National Grid – Yorkshire Green Project Procedural Deadline 3

Comments on Additional Viewpoints

- Volume 8 – Document 8.15 Additional Photomontages (Part 1 of 2)
- Volume 8 - Document 8.15 Additional Photomontages as requested by Examining Authority (Part 2 of 2)

Yorkshire GREEN
Environmental Statement
April 2023
Figure 8.15.3b
Viewpoint C: A19, east of Overton Substation
Photomontage - Year 0

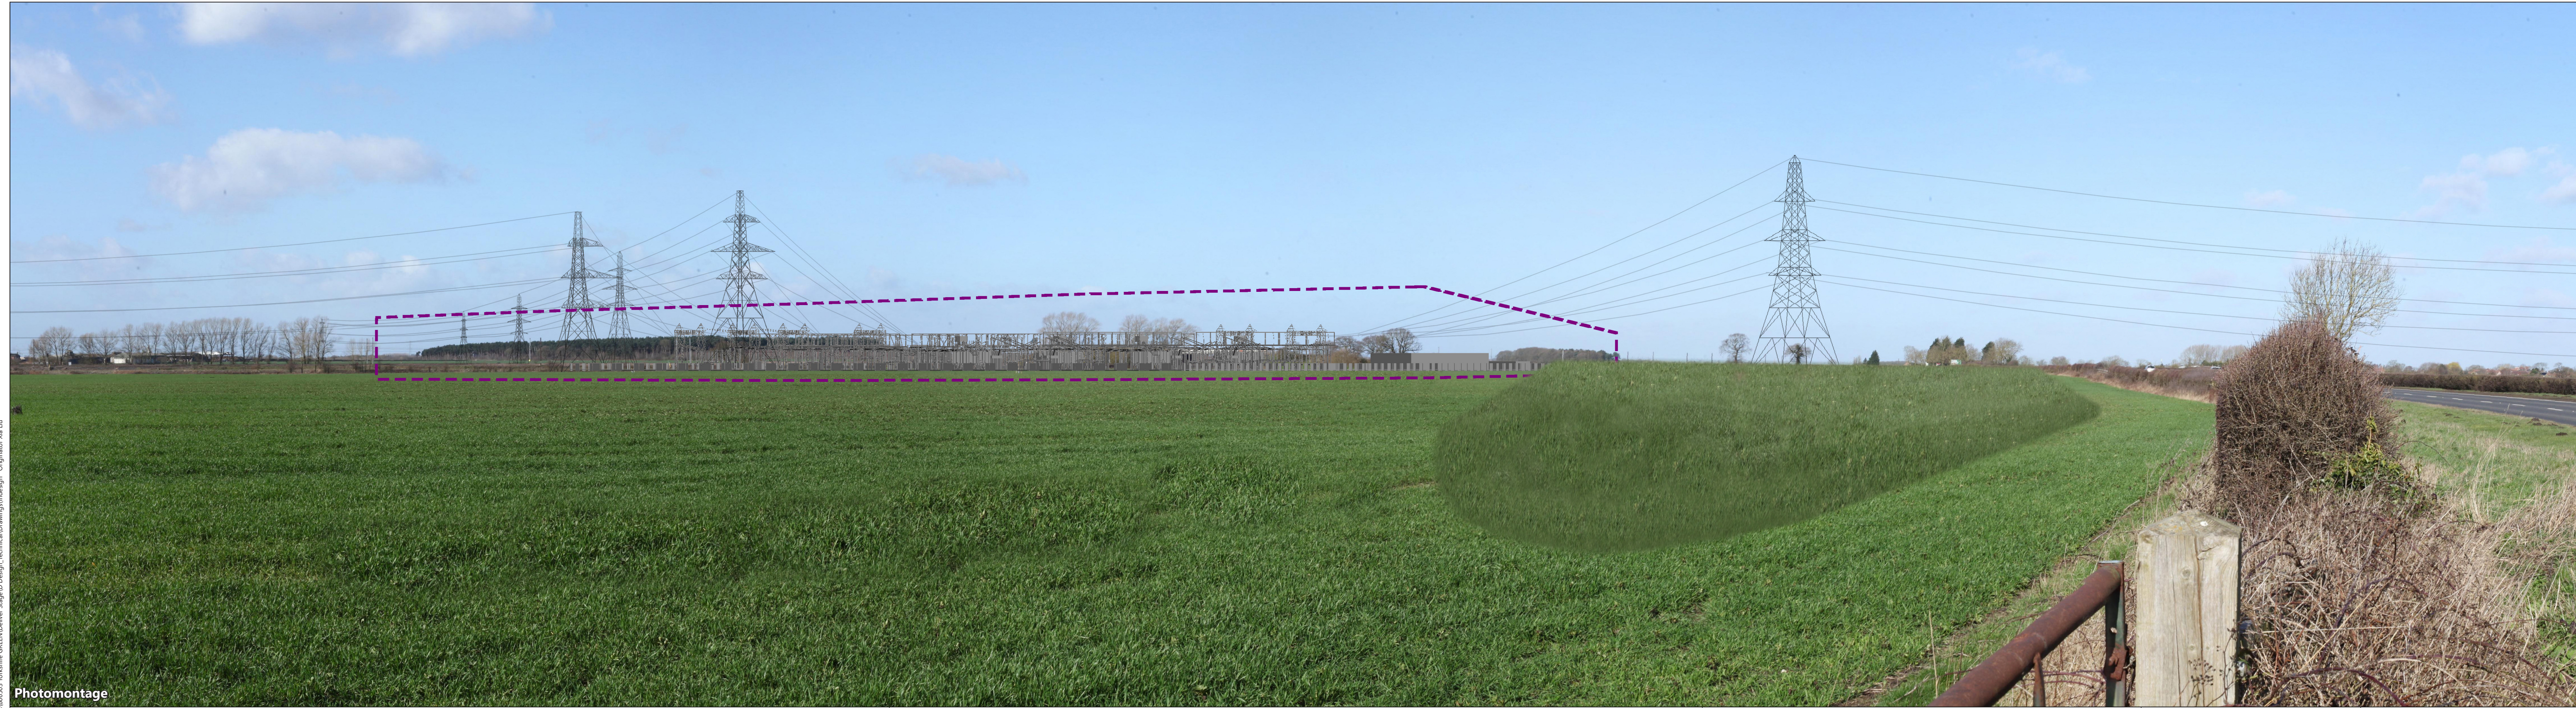
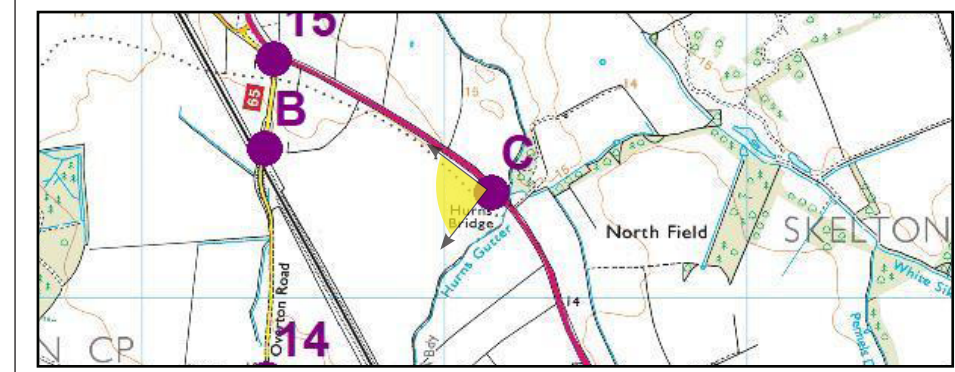
The insulators to the proposed overhead line tower structures have not been included.

To assist with the review of the viewpoint assessment, is the applicant able to confirm the length and location of the proposed mounding & planting along the A19?

Figure 8.15.5b

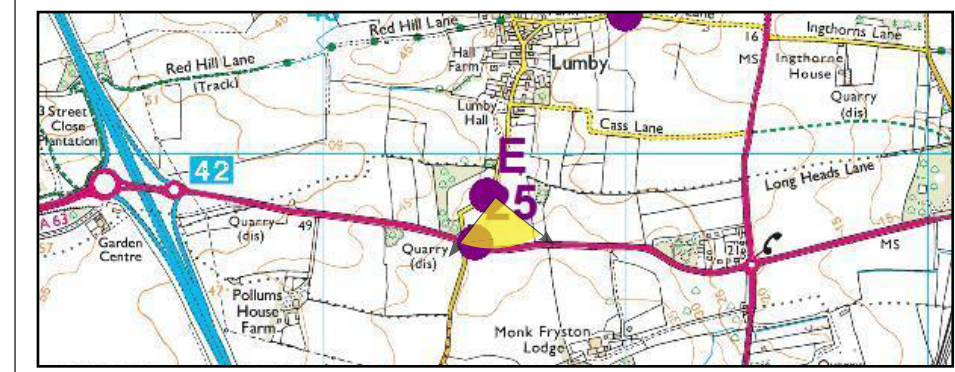
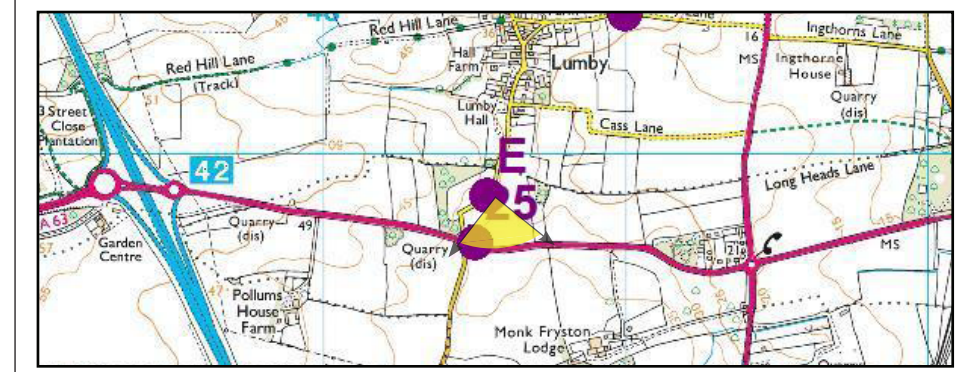
The insulators to the proposed overhead line tower structures have not been included. In addition, the photomontages representing Year 0 and Year 15 do not appear to include the A63 (road) and low hedgerow at the northern edge of the road. These elements are north of the substation and it appears that the mounding has extended over the road and hedgerow. As a result the proposed mounding (and planting) appear closer to the viewpoint compared with the actual situation and this will have a bearing on the visual assessment judgements.
